EL PASO COUNTY

OFFICE OF THE COUNTY ATTORNEY CIVIL DIVISION

October 9, 2019

VR-17-017 Hadden Heights No. 2, Lot 18B (Contreras)
Vacation and Replat

HADDEN HEIGHTS NO. 2
DRAWN BY: MWW CHECKED BY: JWT DATE: 08/31/17
JOB NO.: 16003900 DWG: 16003900-AP.DWG SHEET 1 OF 1

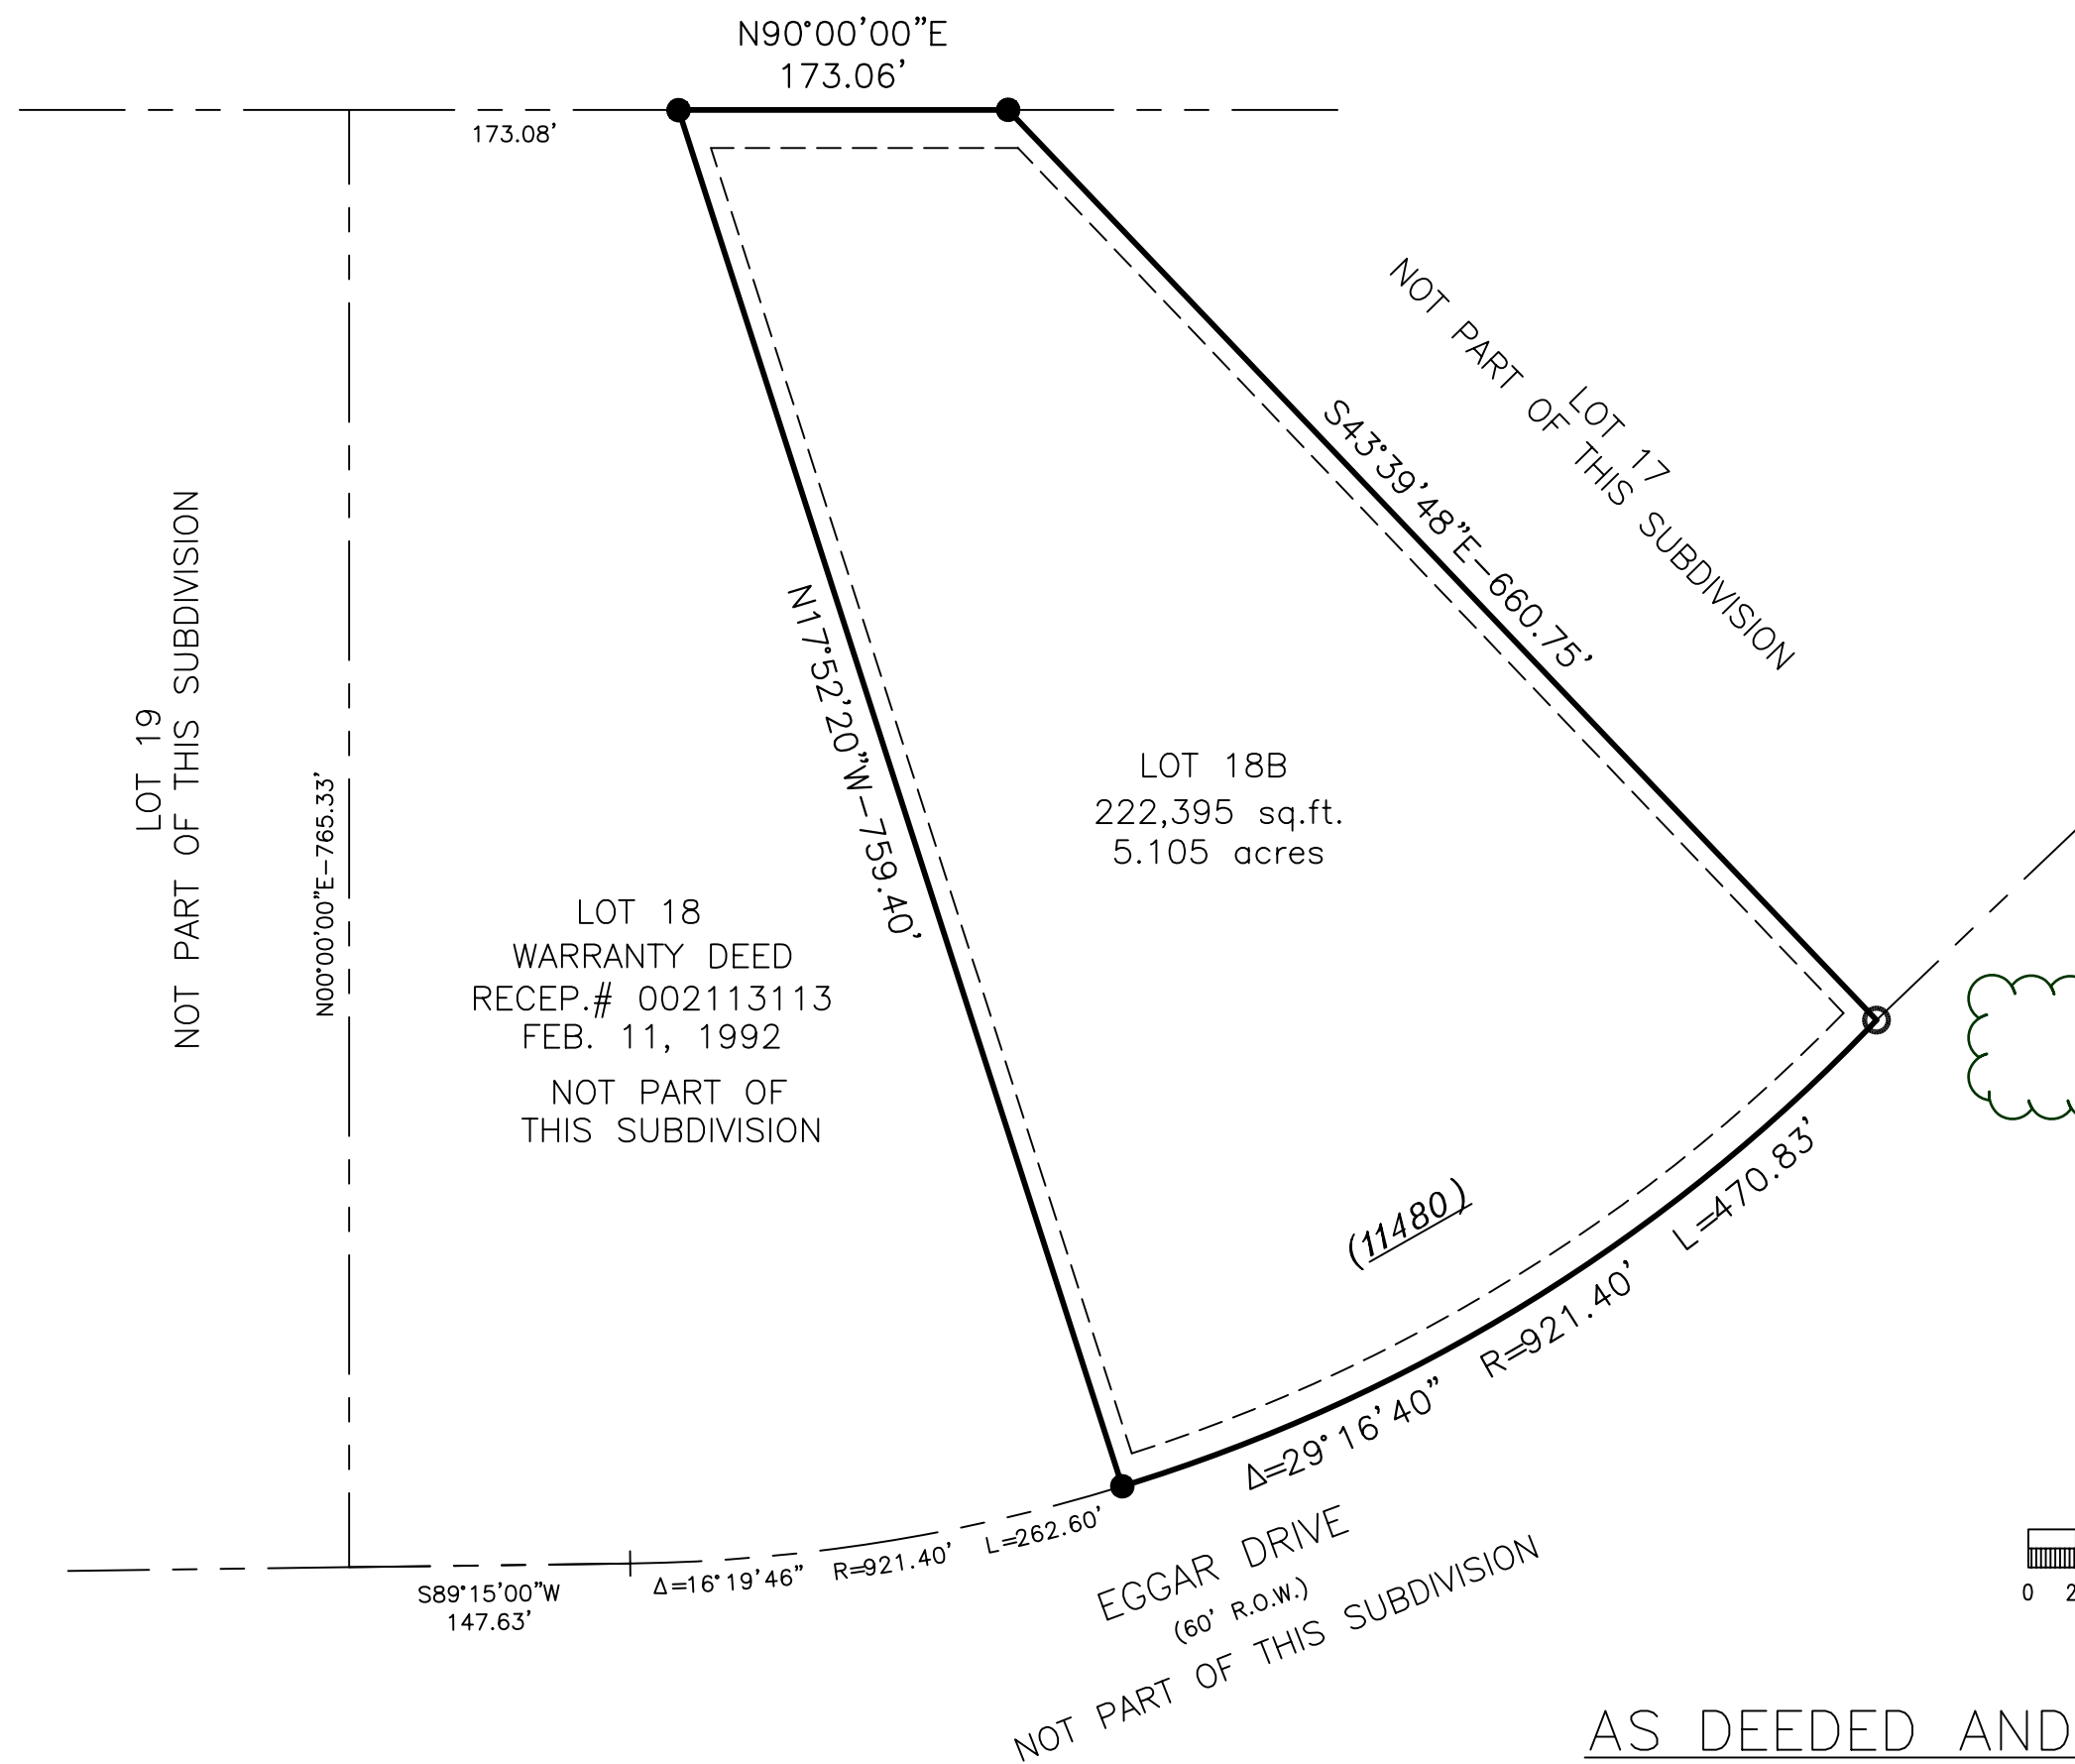
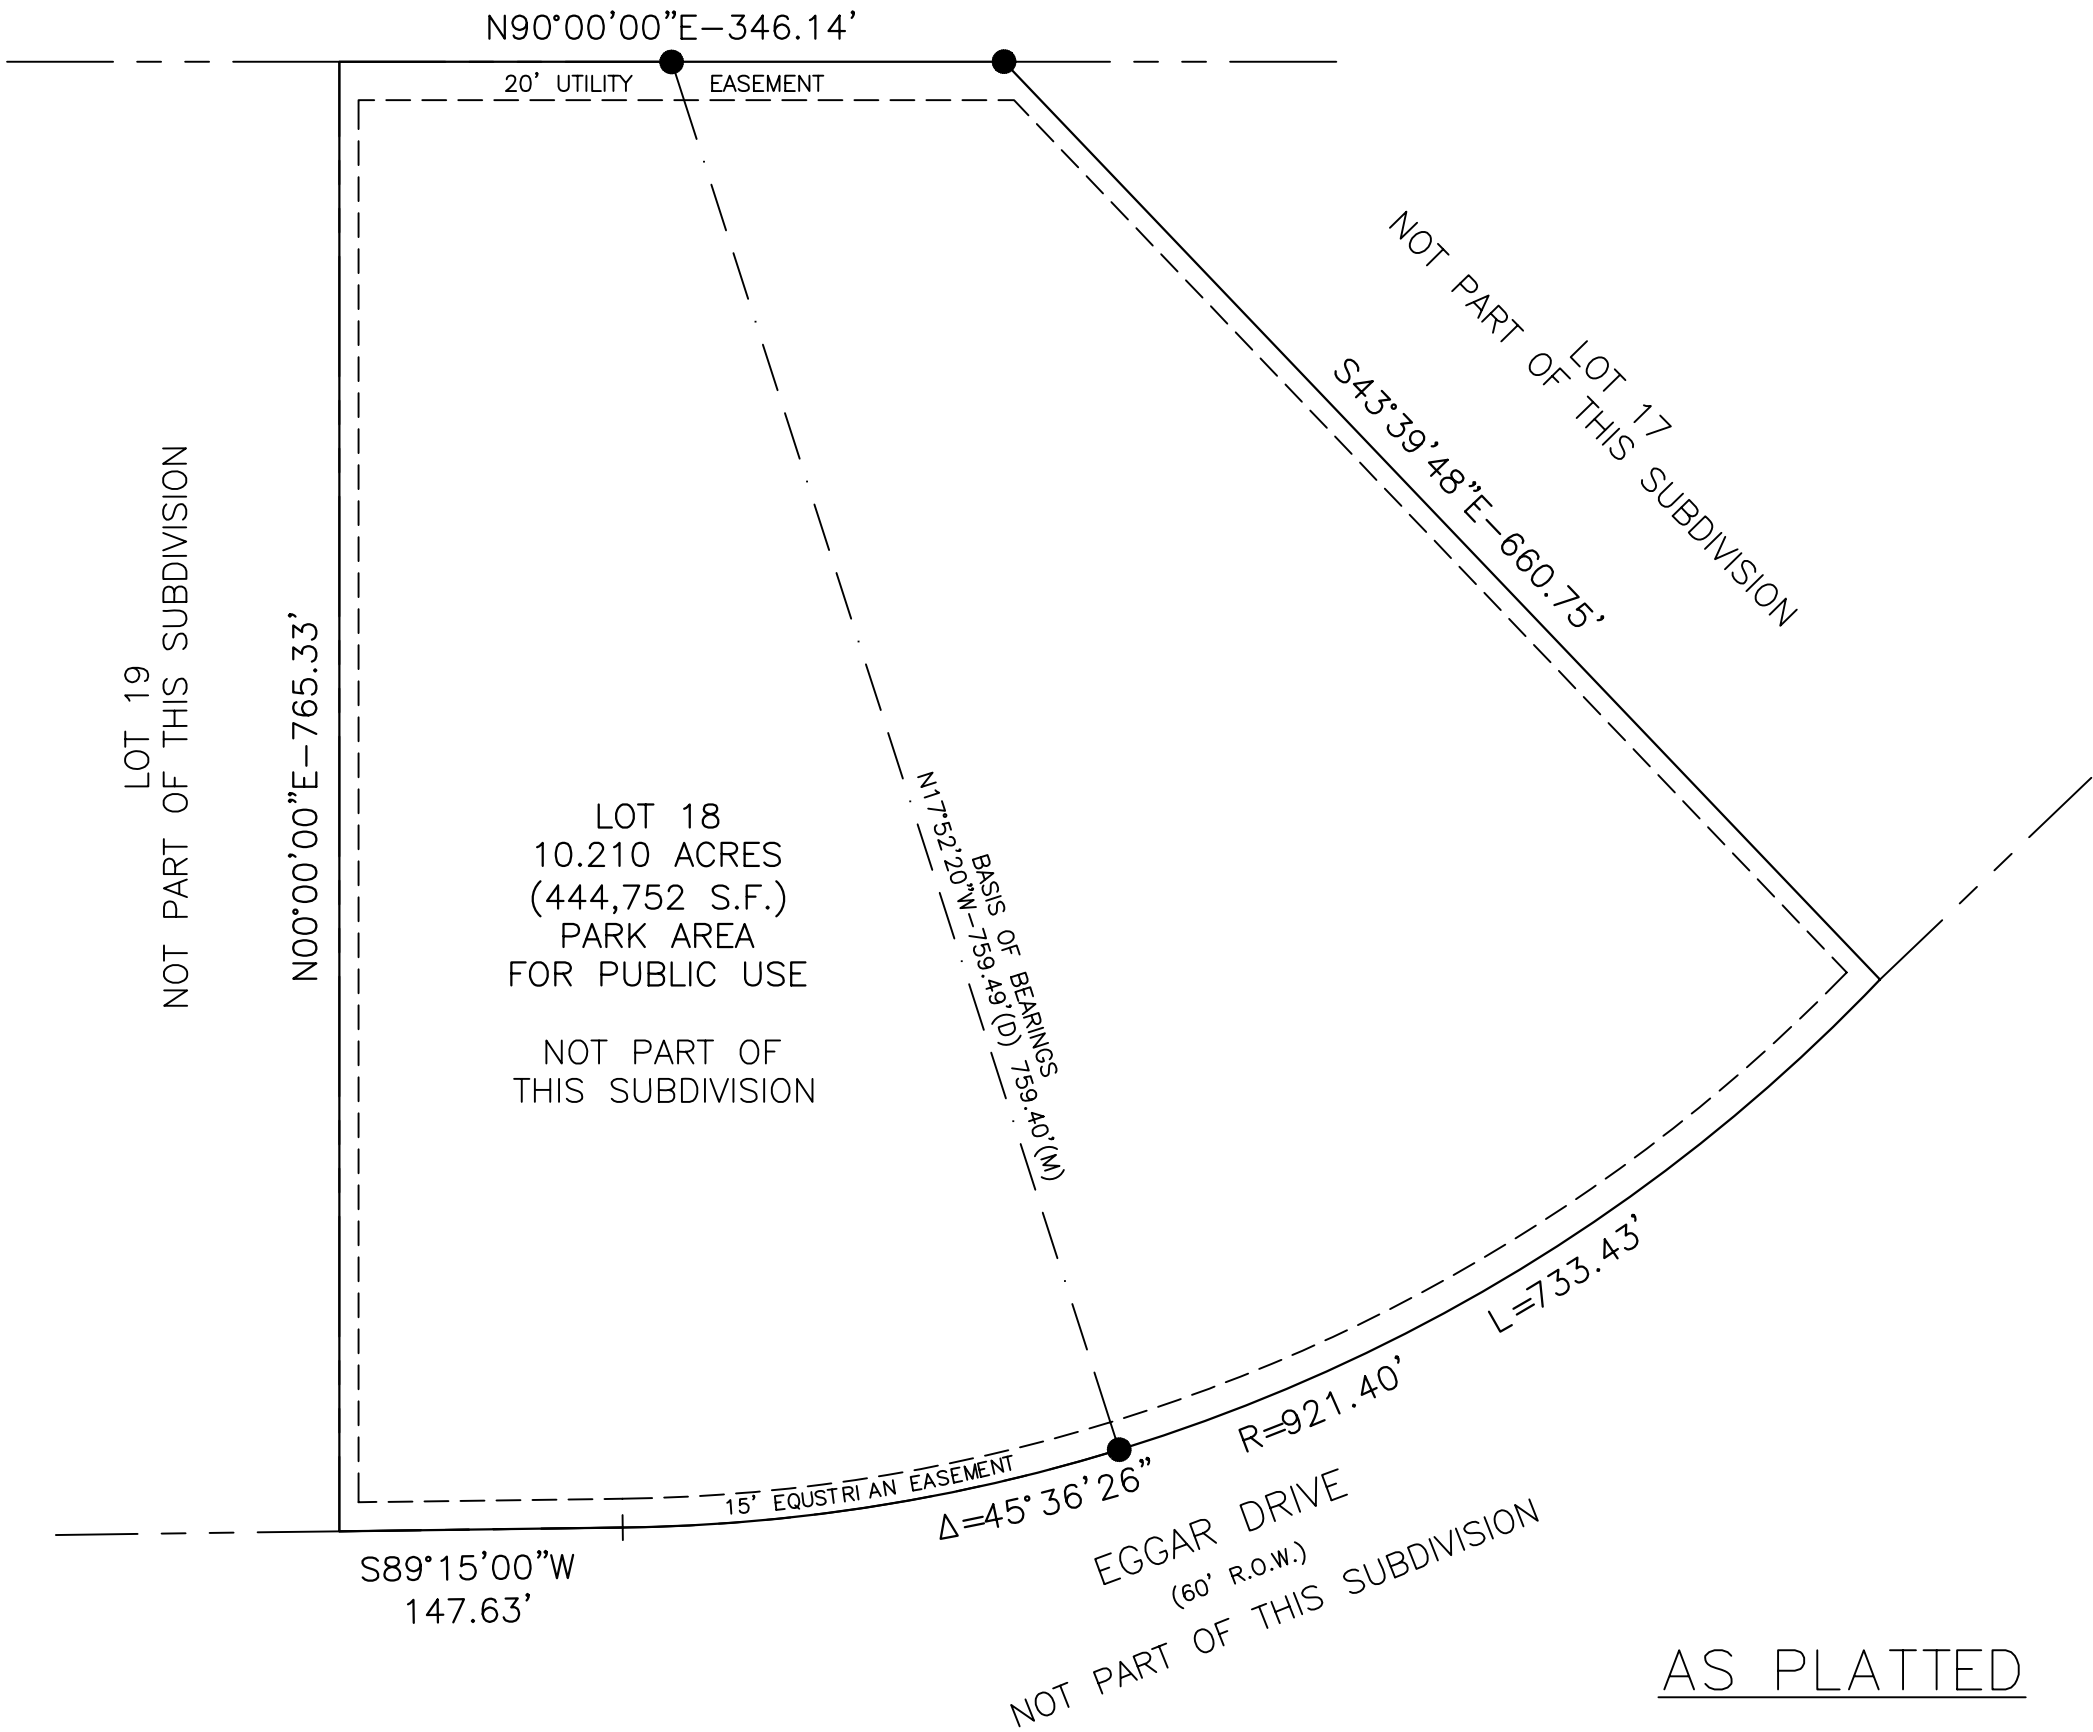
F. The following plat note shall be added to advise landowners of potential limited water supplies in the Denver Basin:

“Water in the Denver Basin Aquifers is allocated based on a 100 year aquifer life; however, for El Paso County planning purposes, water in the Denver Basin Aquifers is evaluated based on a 300 year aquifer life. Applicants, the Home Owners Association, and all future owners in the subdivision should be aware that the economic life of a water supply based on wells in a given Denver Basin aquifer may be less than either the 100 years or 300 years used for allocation indicated due to anticipated water level declines. Furthermore, the water supply plan should not rely solely upon non-renewable aquifers. Alternative renewable water resources should be acquired and incorporated in a permanent water supply plan that provides future generations with a water supply.”
